### **East Anglia One North and East Anglia Two Offshore Wind Farms**

**Planning Inspectorate Reference: EA1N – EN010077 &  
EA2 – EN010078**

**Deadline 7 – 4 March 2021**

**East Suffolk Council's Response to Deadline 7**

### Bat Roost and Commuting/Foraging Habitat Results

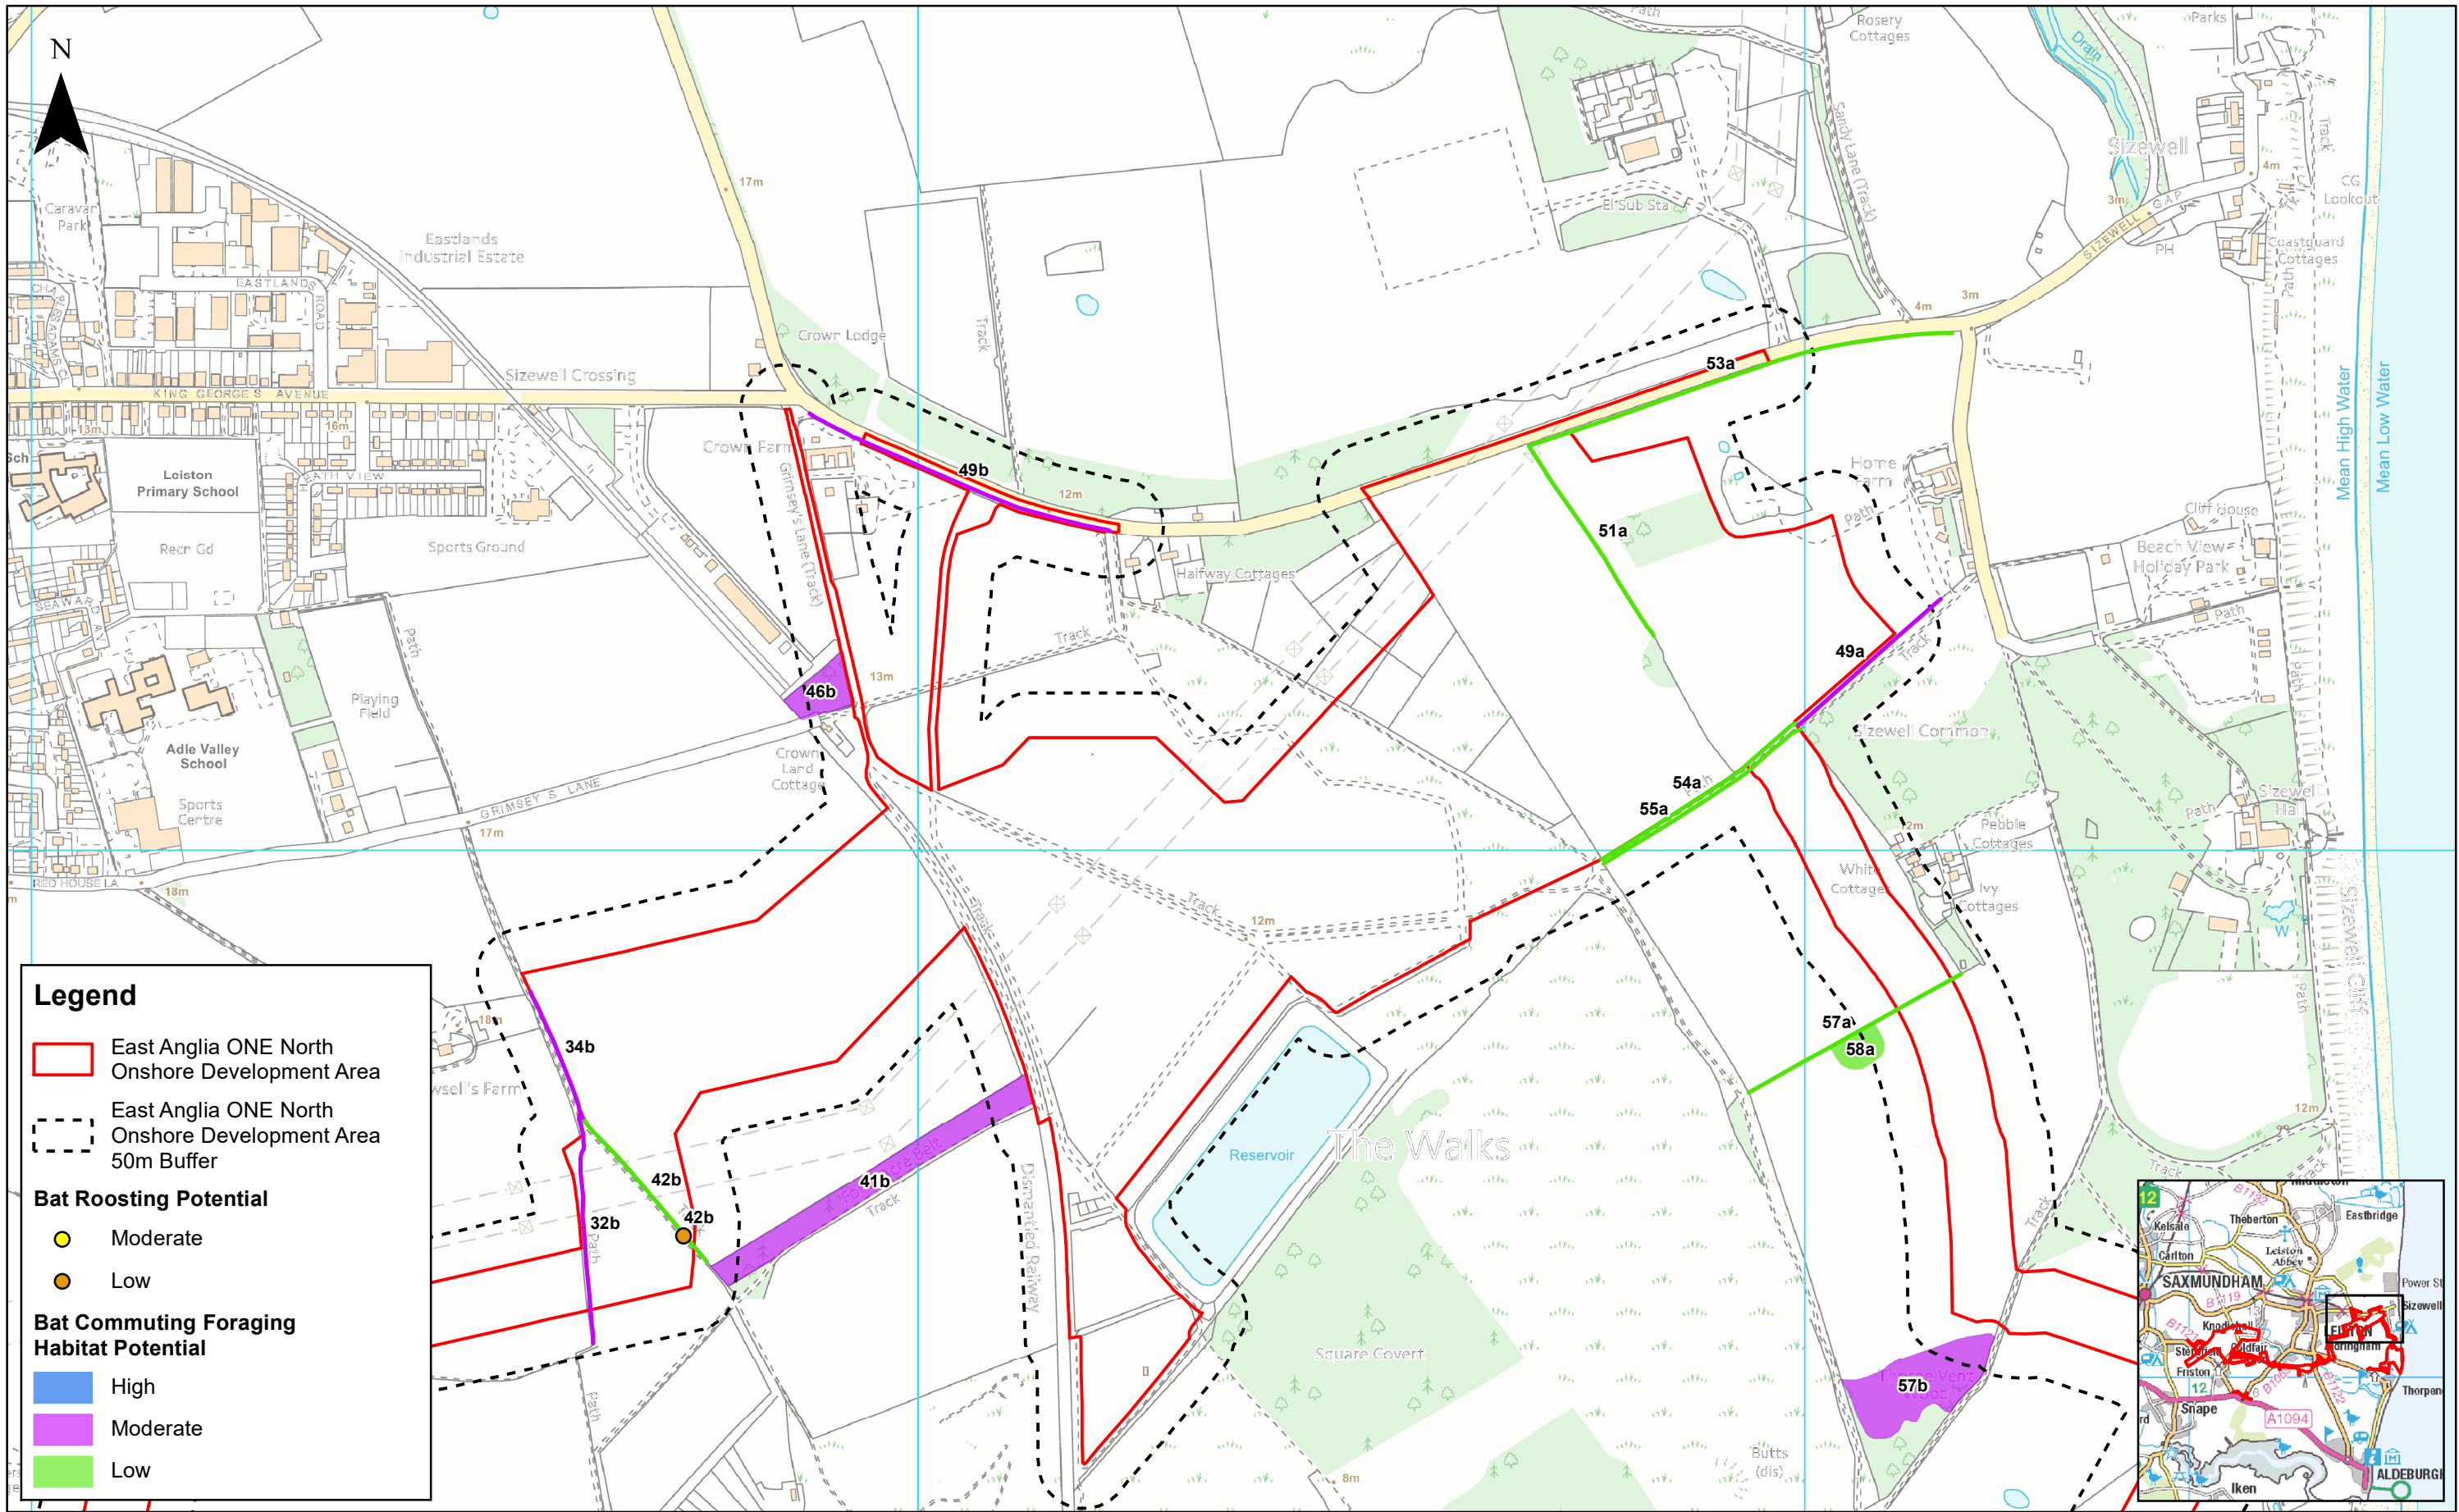
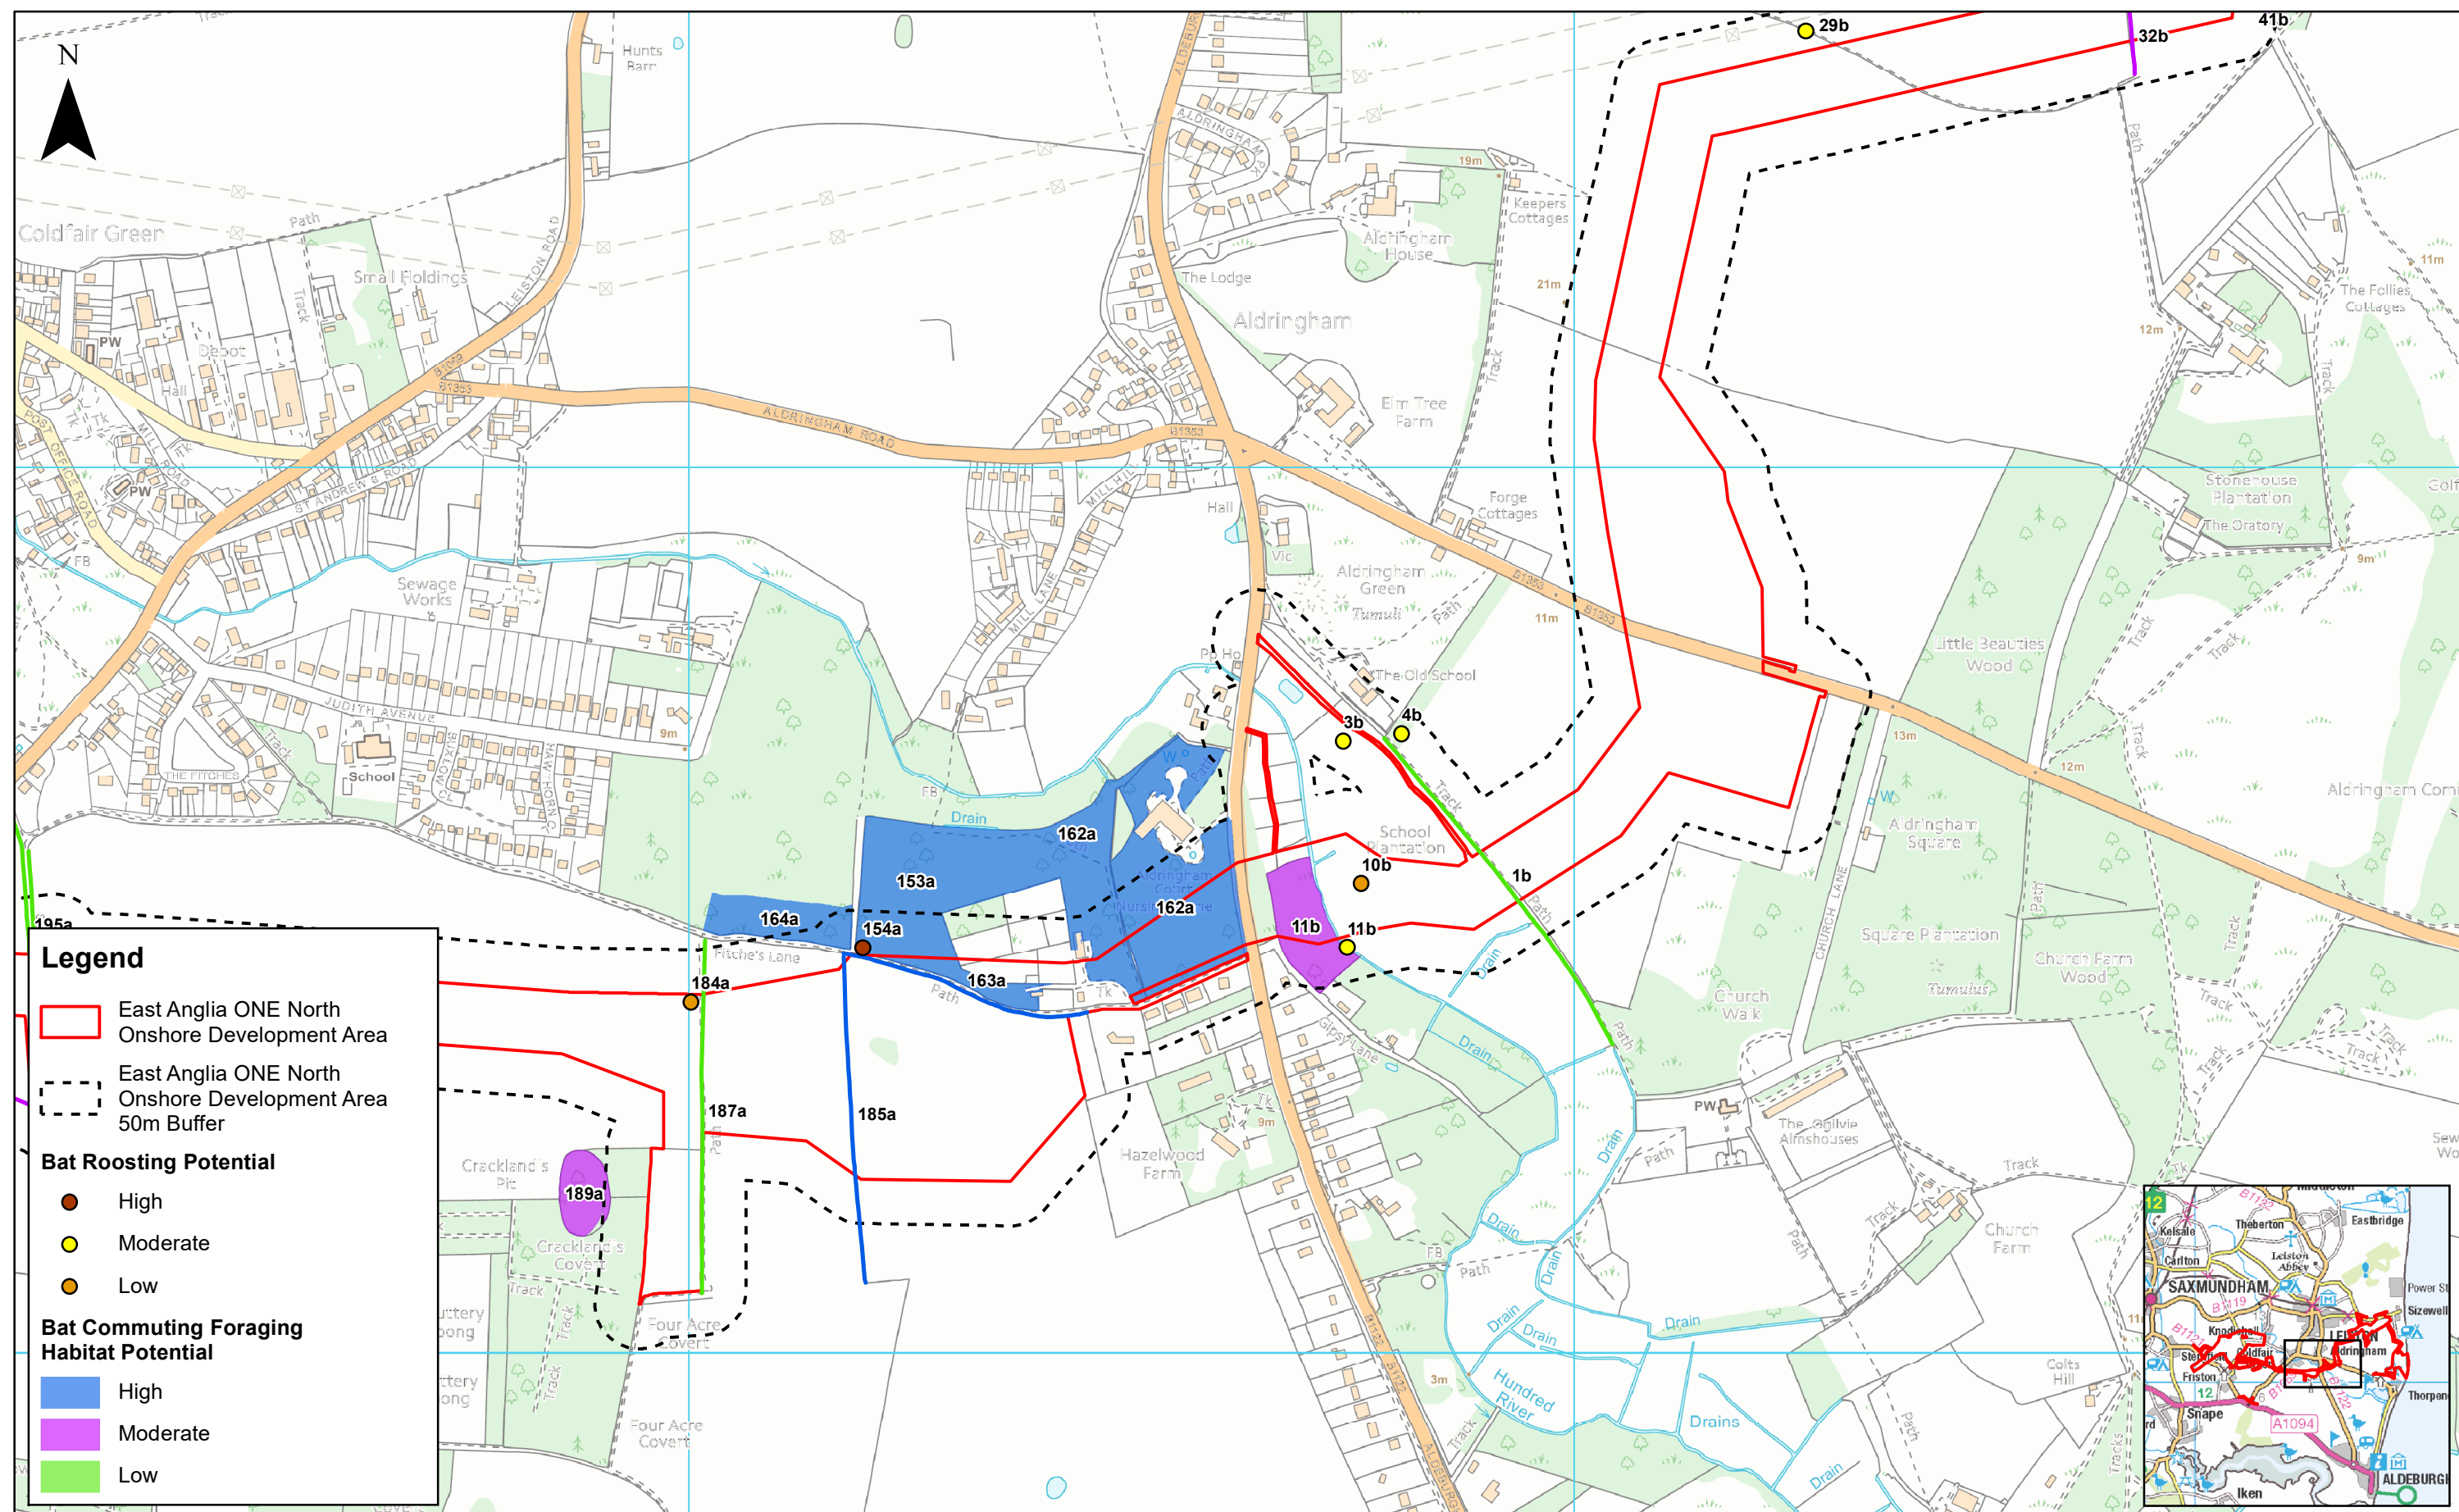
- 2.16. Bats - Whilst the Applicants' response to ESC's Deadline 5 comment (REP5-048) on this matter is noted (Section 2.3, ID1, REP6-026), the Council maintains the opinion that the absence of brown long-eared bats from the survey results is likely an under recording of this species in the area rather than a complete absence of the species. All of the bat survey techniques used (emergence/re-entry, activity transects and static bat detector) rely primarily on acoustic recording and the nature of brown long-eared bat behaviour (particularly the absence of echolocating or very quiet echolocating) is an acknowledged limitation of this type of surveying. Further comment on this matter was made at Issue Specific Hearing 7 (ISH7, REP6-075).

2.17. We also note the comment in the relation to maternity bat roosts being present at other substation sites (Section 2.3, ID2, REP6-026). As set out in our Deadline 5 response (REP5-048), and acknowledged in the Applicants' comments on this matter, different bats are affected by noise to different degrees and the presence of a maternity colony of one species in such a location does not mean that all other species have not been affected. Further information on the species present roosting within existing substations would have been beneficial.
